Building Permit Request for 183 Ribbon Oak Court, Sanford, North Carolina 27332

Requested Actions for Approval:

Revisions to Deck Addition Plans

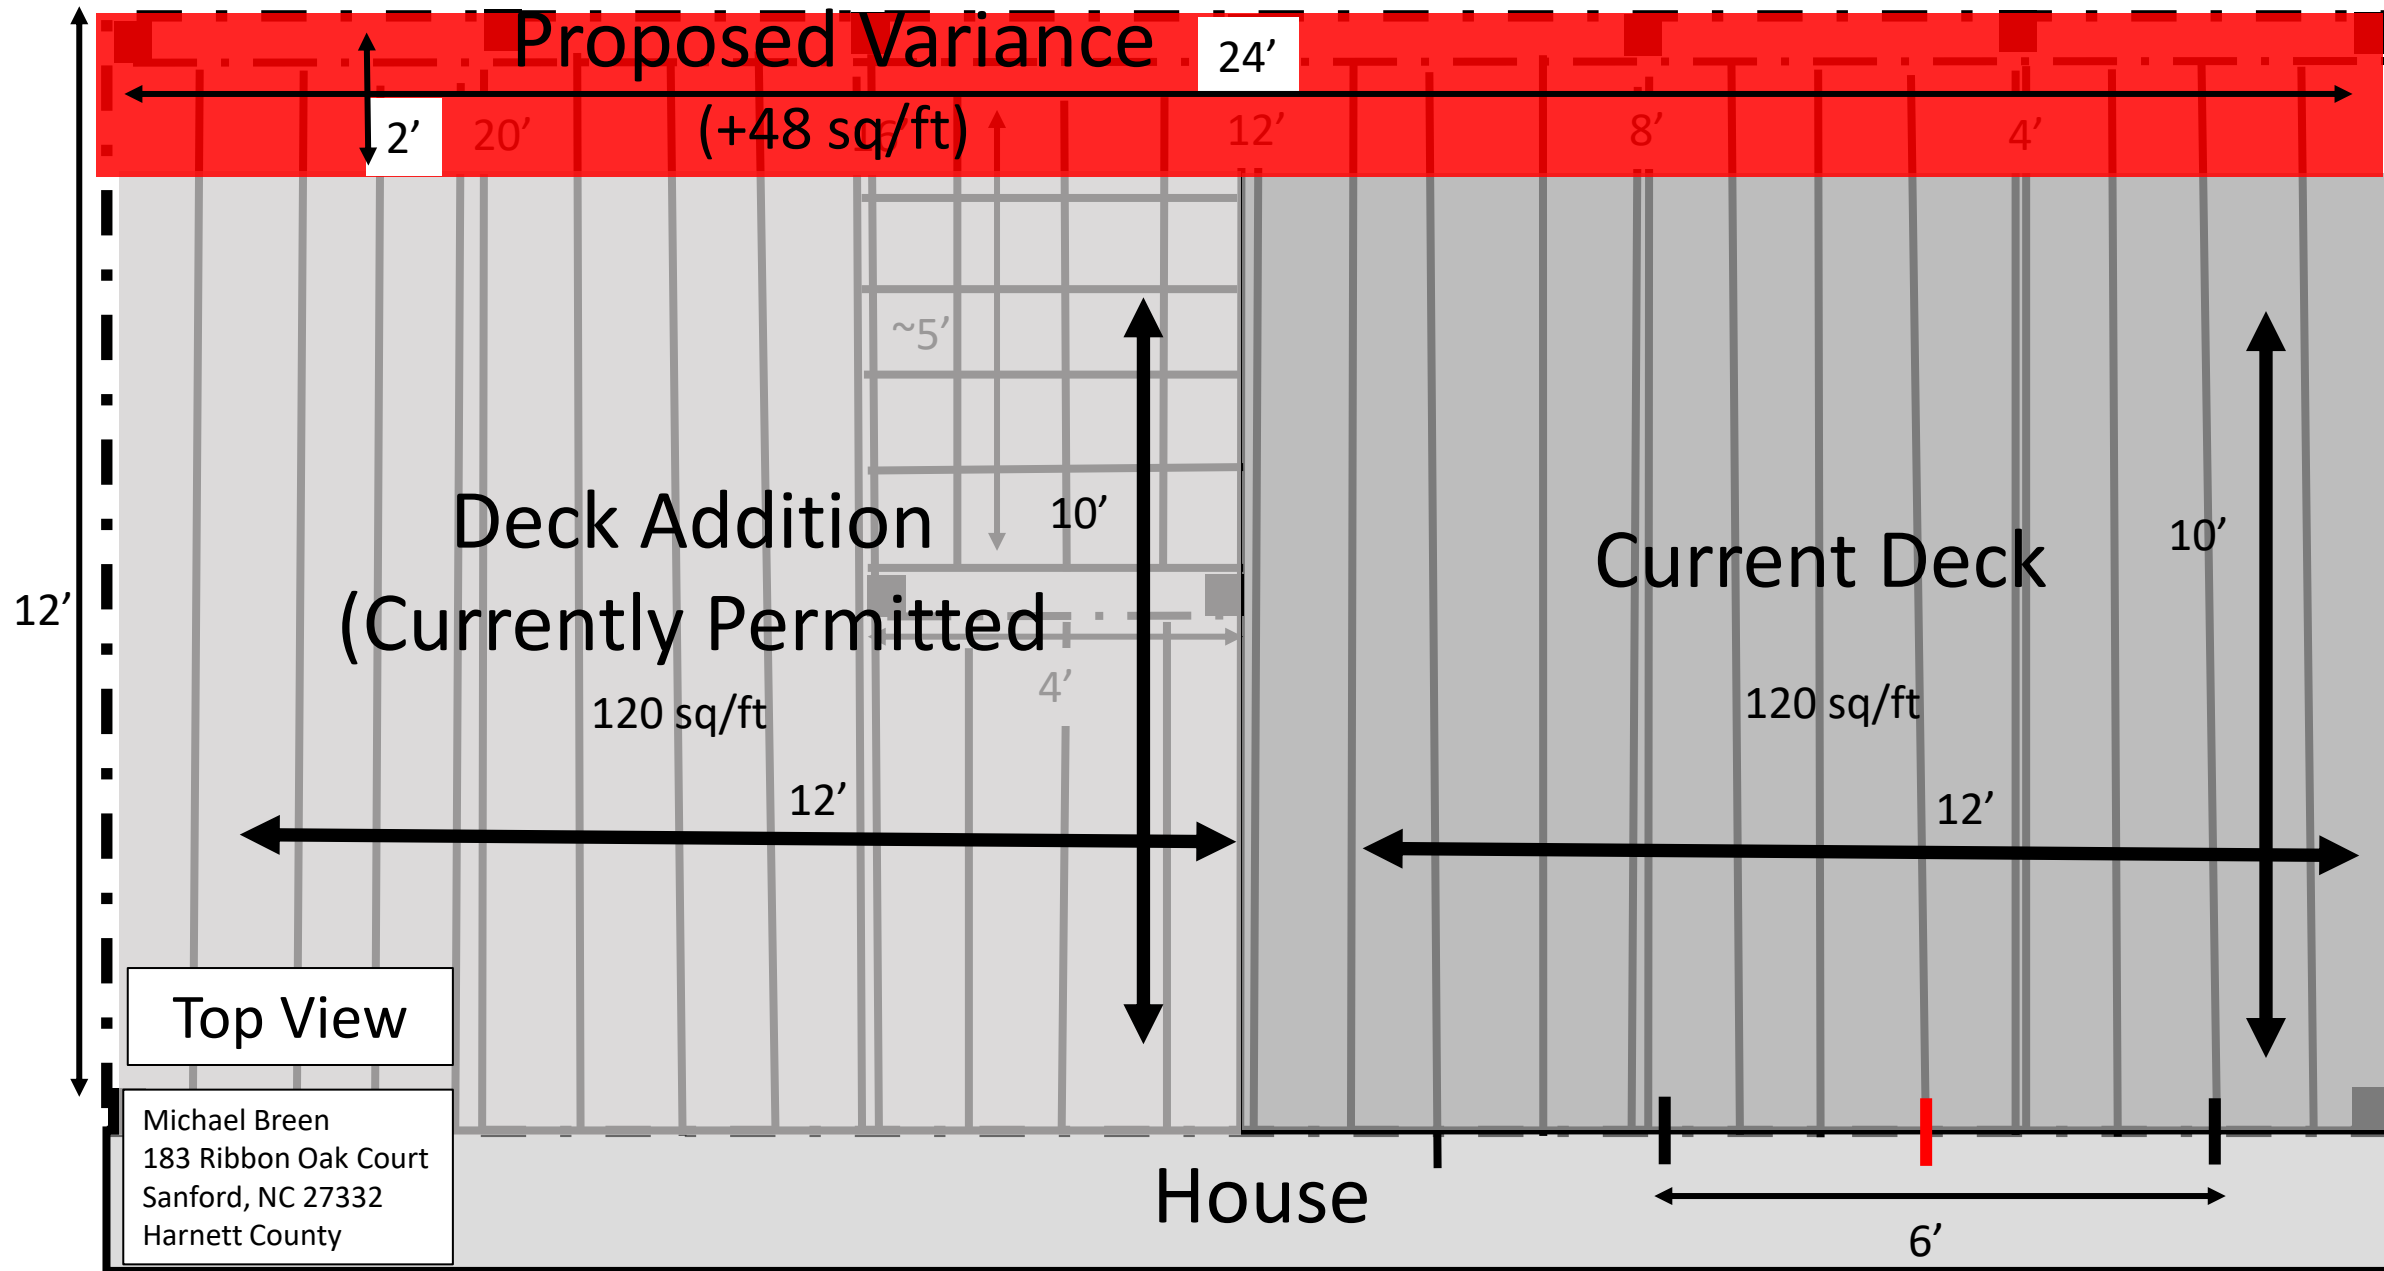
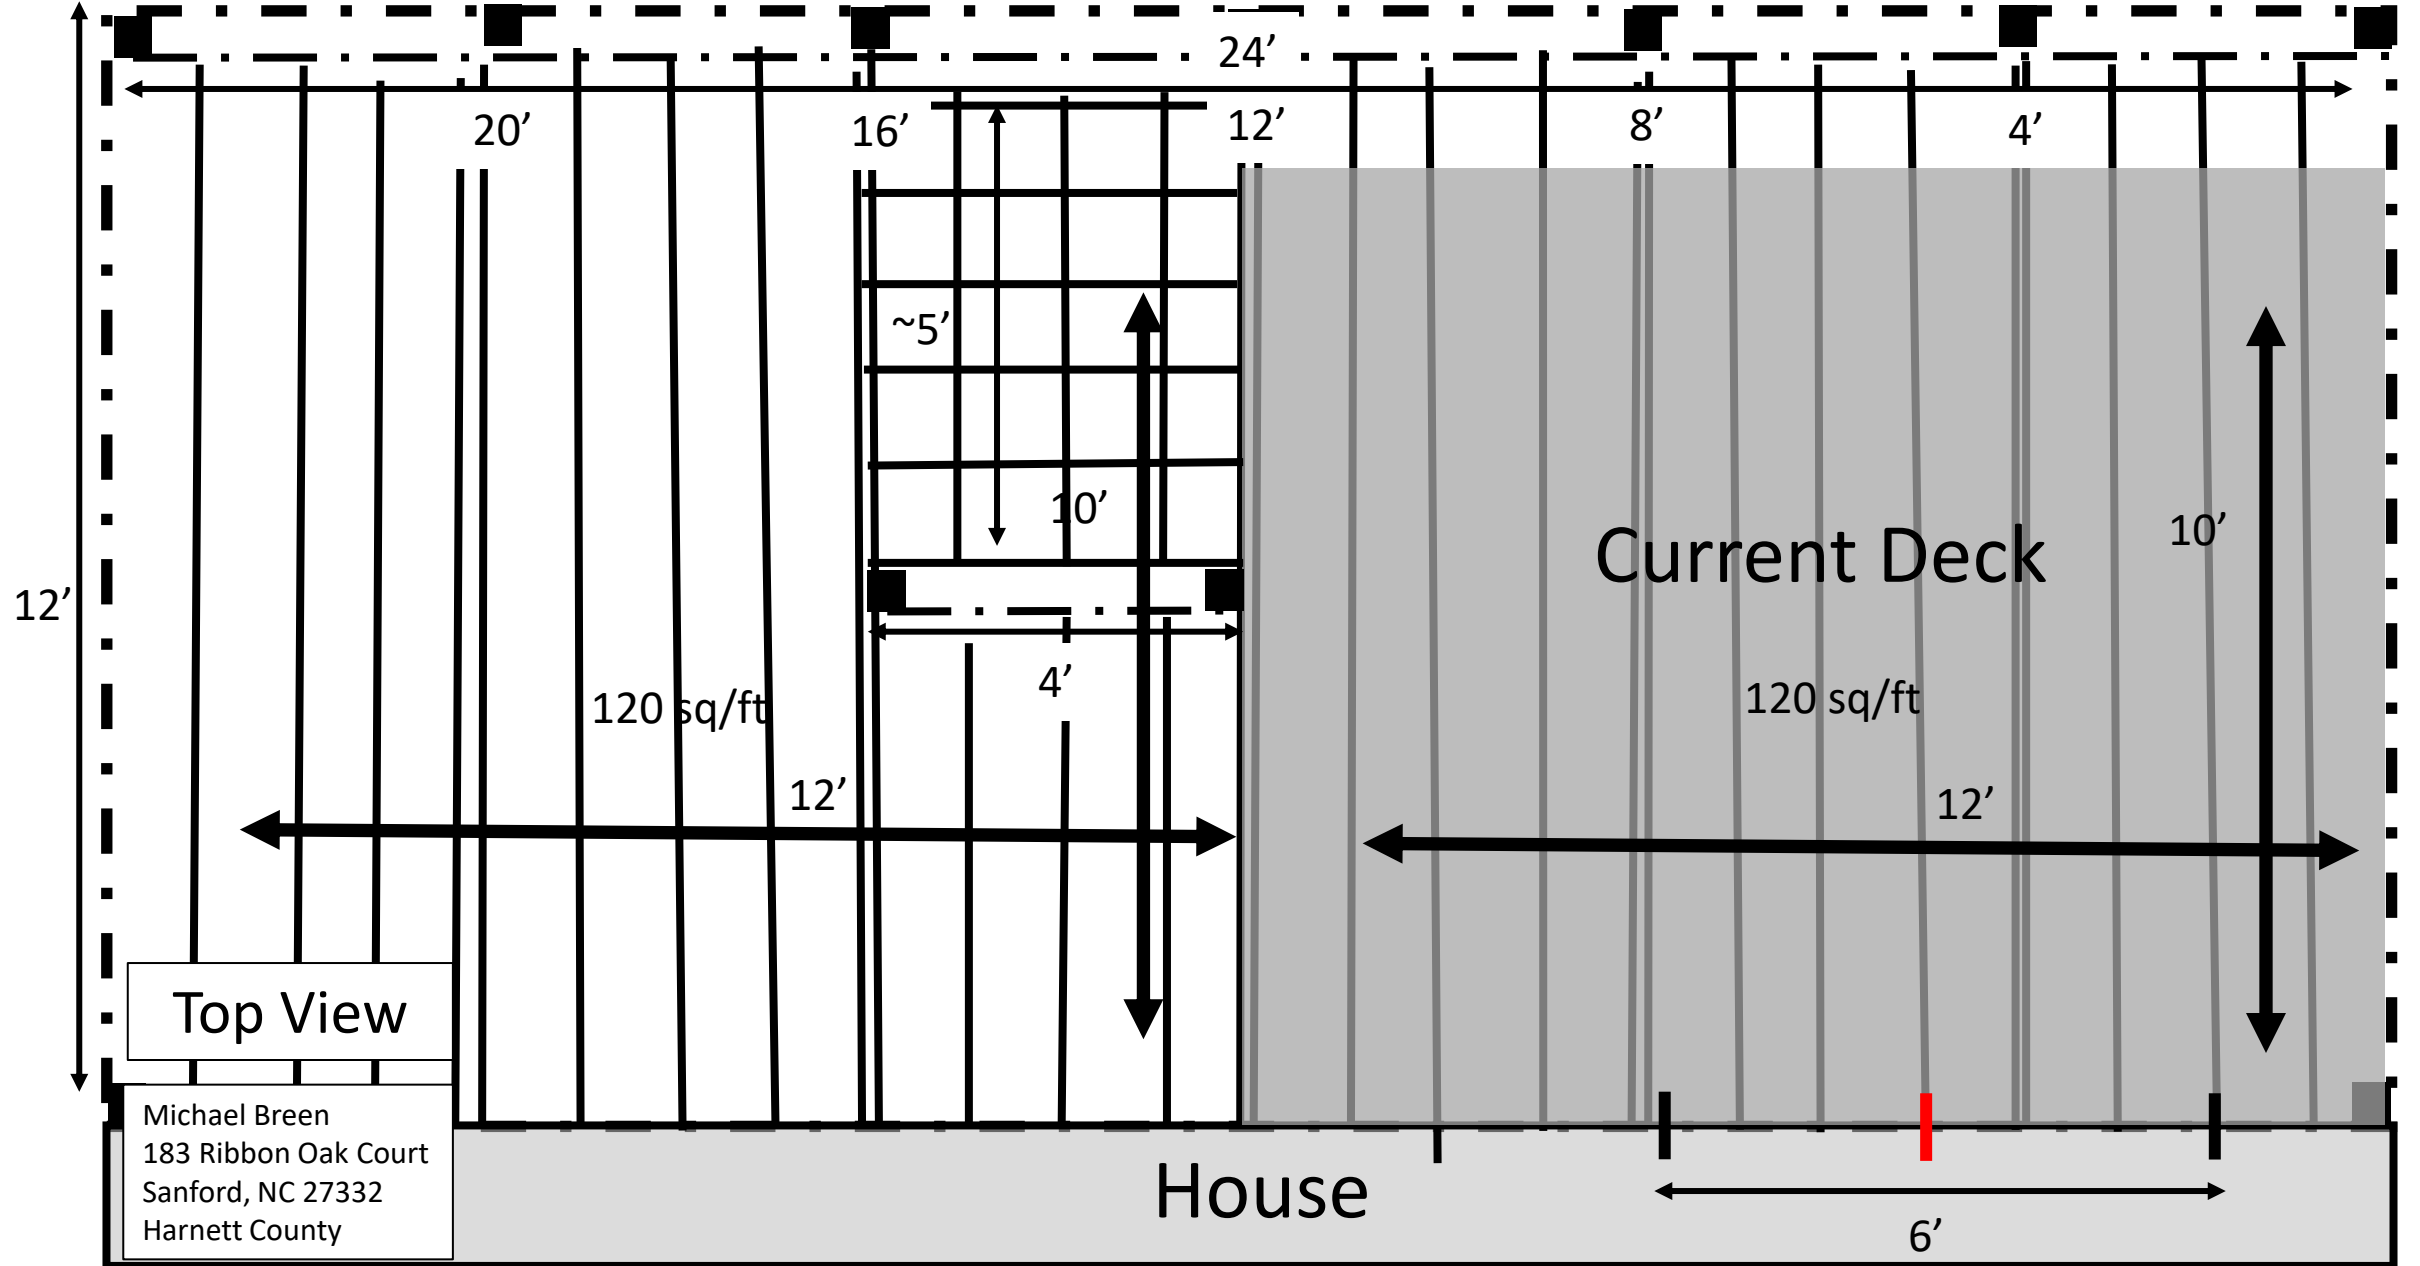
Amendment to Add to Overall Finished Dimension: 2x24' (48 sq/ft).

Planned Overall Finished Dimension: 12x24' (288 sq/ft).

Total Joist Span Does Not Exceed 12'.

2x8" Joists Changed to 2x10" (12" – O.C.).
